A303 Amesbury to Berwick Down

TR010025

Deadline 2
8.10.13 Landscape and Visual (LV.1)

Landscape and Visual (LV.1)

Area of Search Field Work and Initial Assessment

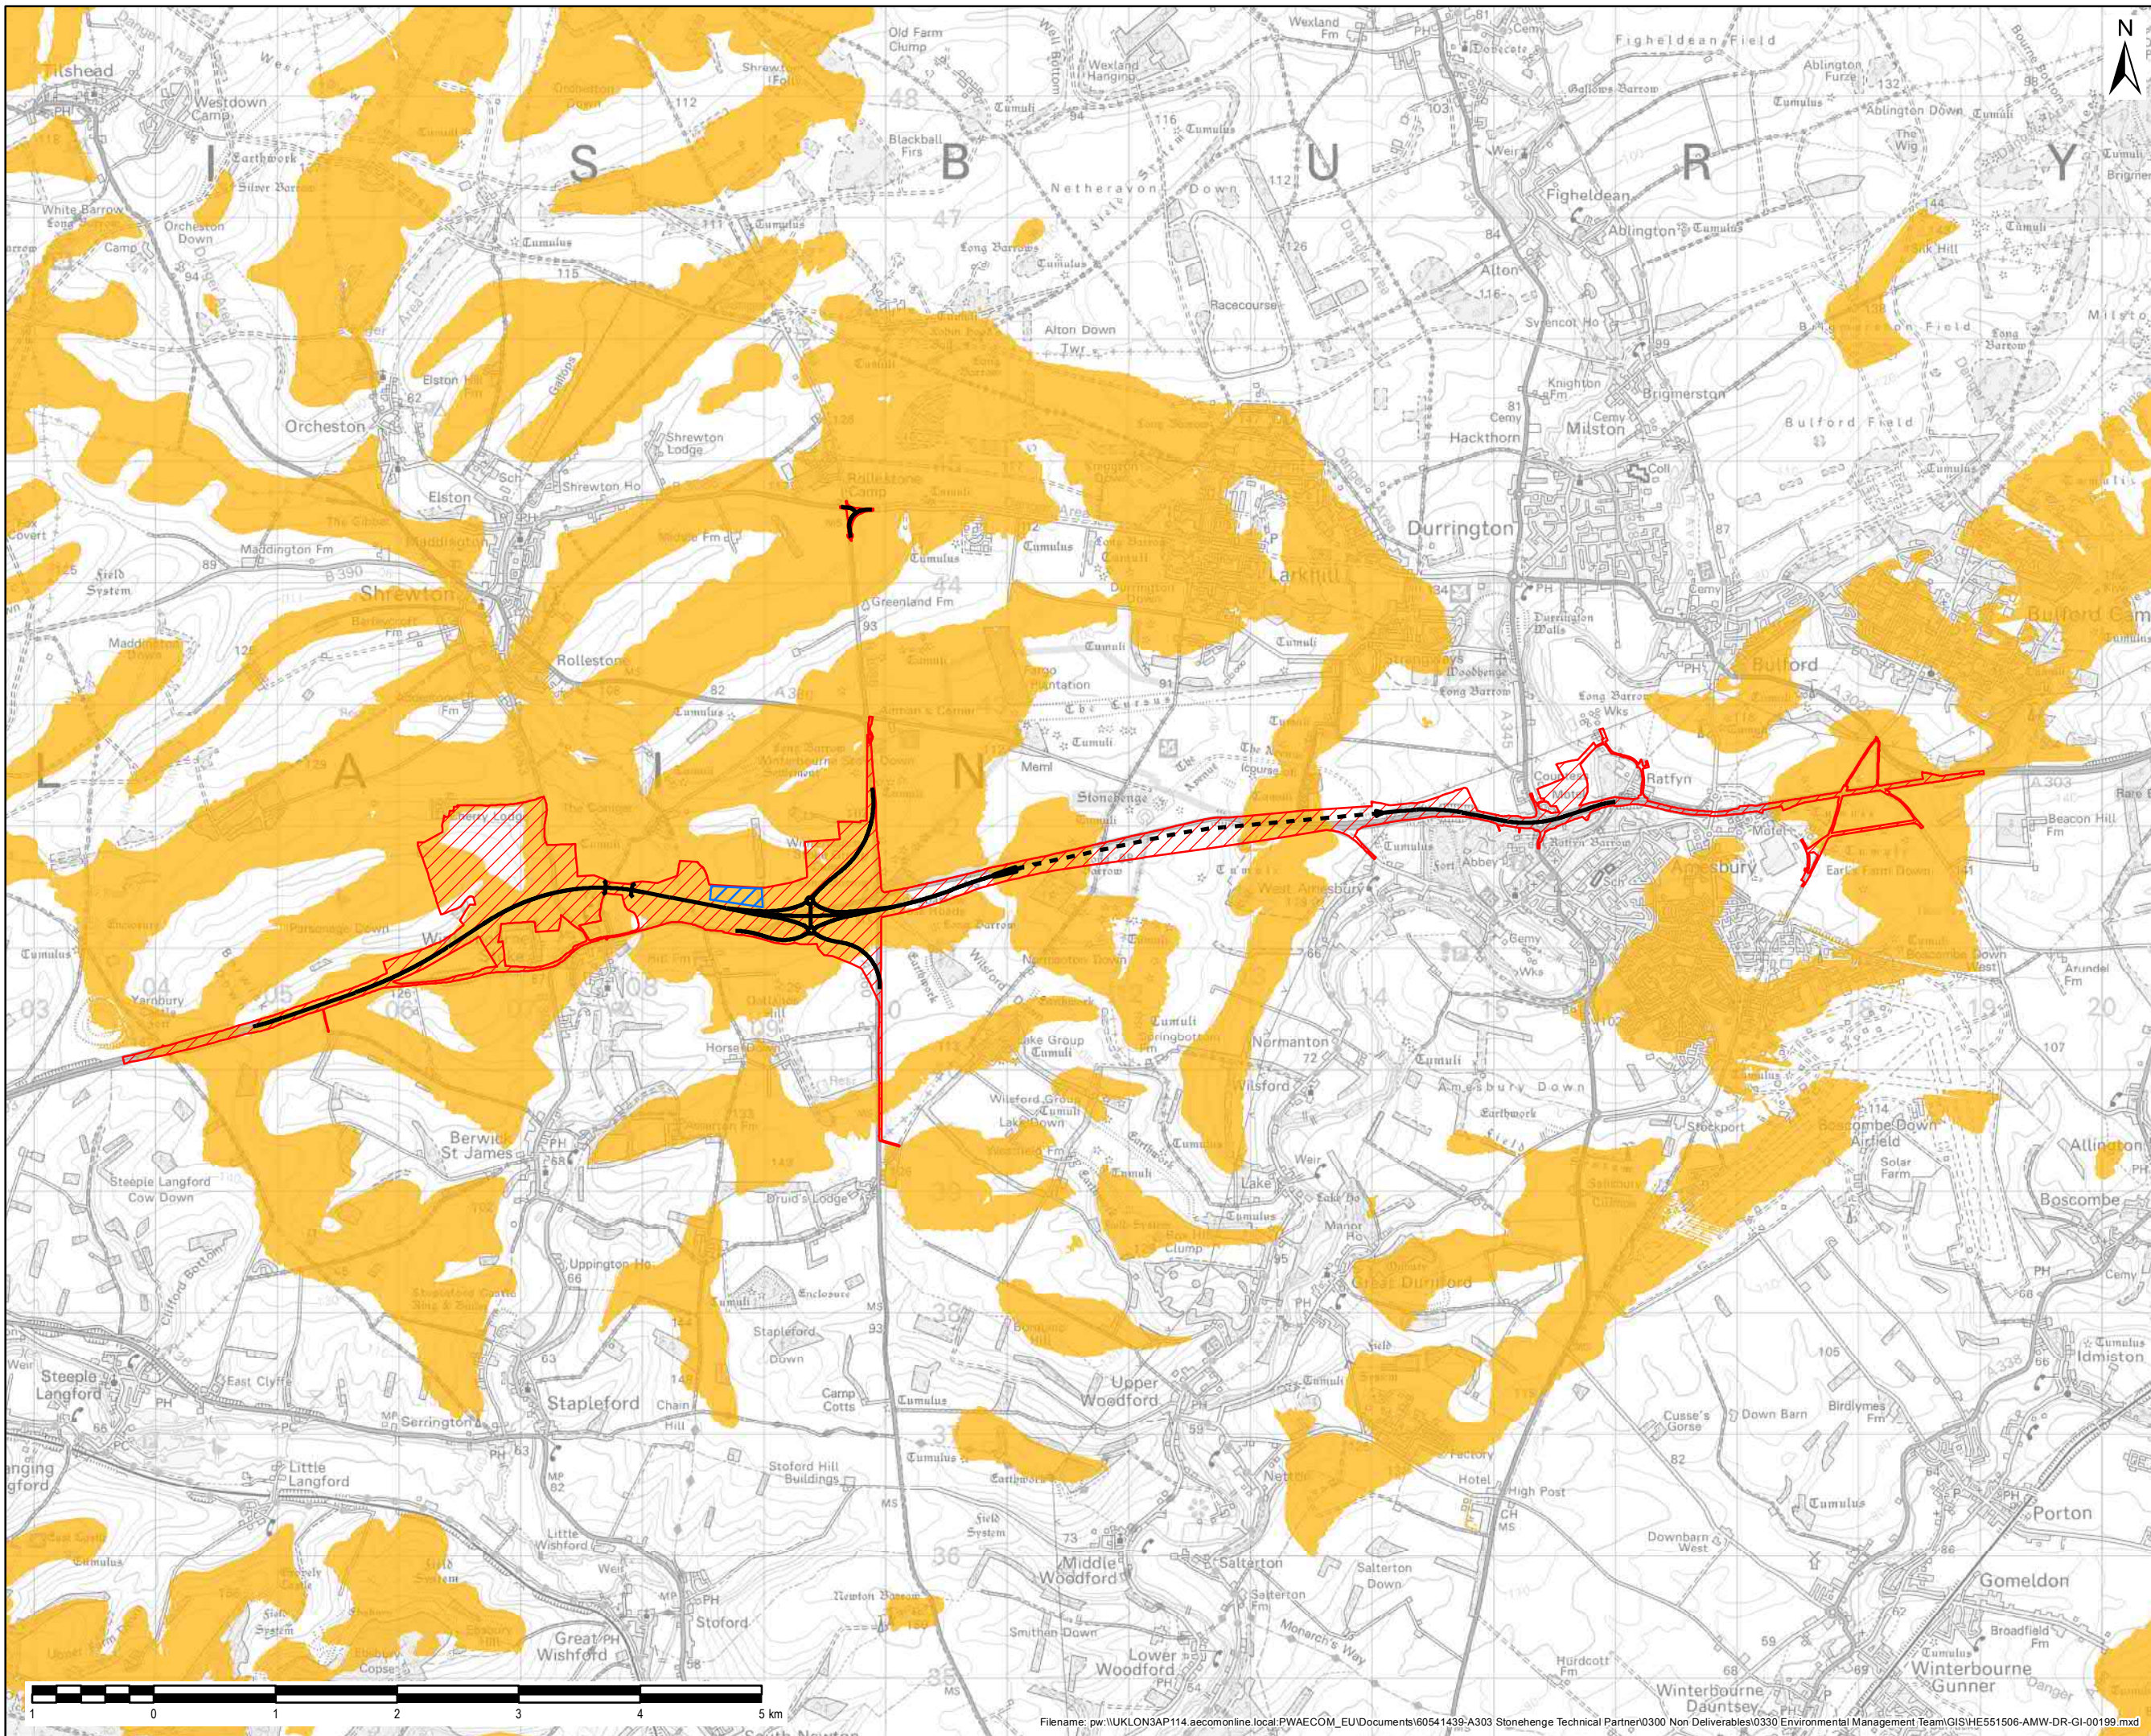
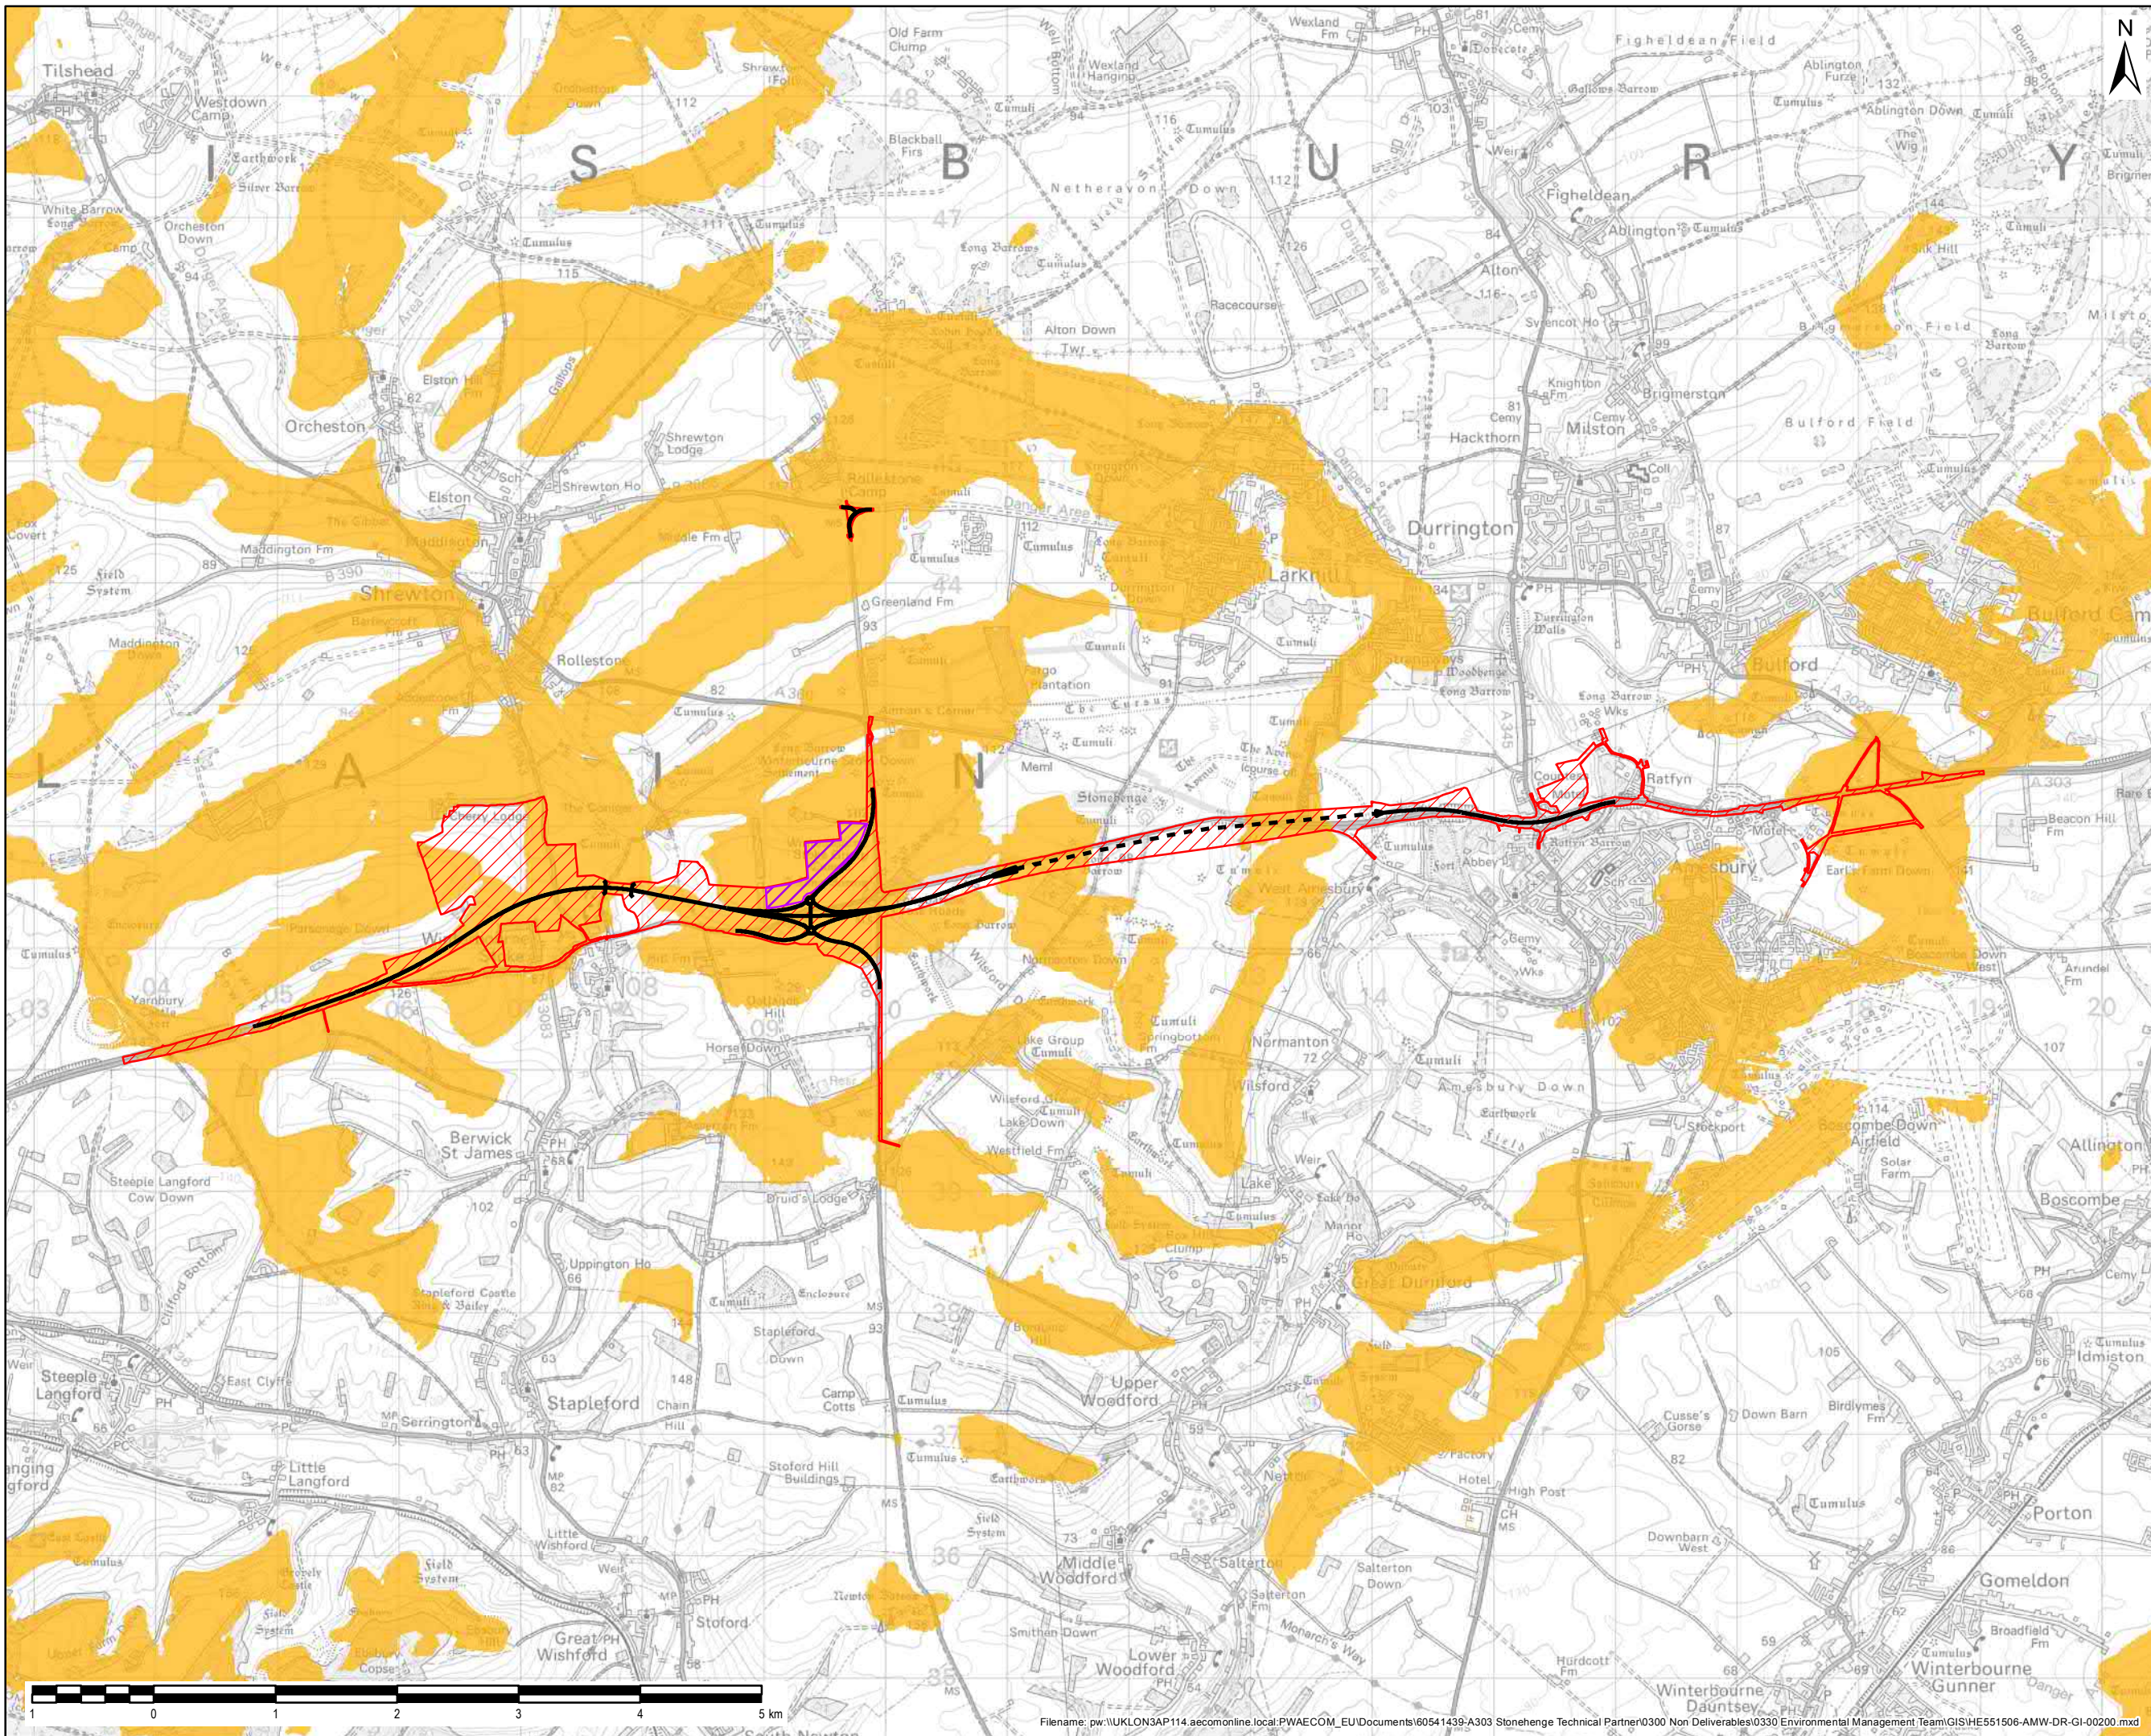
- i. Where is Windmill Hill?
- ii. Has full account been taken of the possibility of significant views from elevated viewpoints both within and outside the study area, such as Beacon Hill and the location of the nearby radio masts?

5. Outside of the study area, elevated viewpoints within LVIA Appendix 7.3 [APP-223] are:
- Elevated ridgelines to the north and west of Shrewton (View 1 at c.120m AOD and View 2 at c. 115m AOD);

- Elevated ridgelines at Durrington (View 3 c.120m AOD);
 - Sides of the Wylde Valley (View 4 c.125m AOD); and
 - Avon Valley (View 5 c.120m AOD).
6. Therefore, the LVIA has considered representative elevated viewpoints as part of the assessment of likely visual effects from the Scheme.
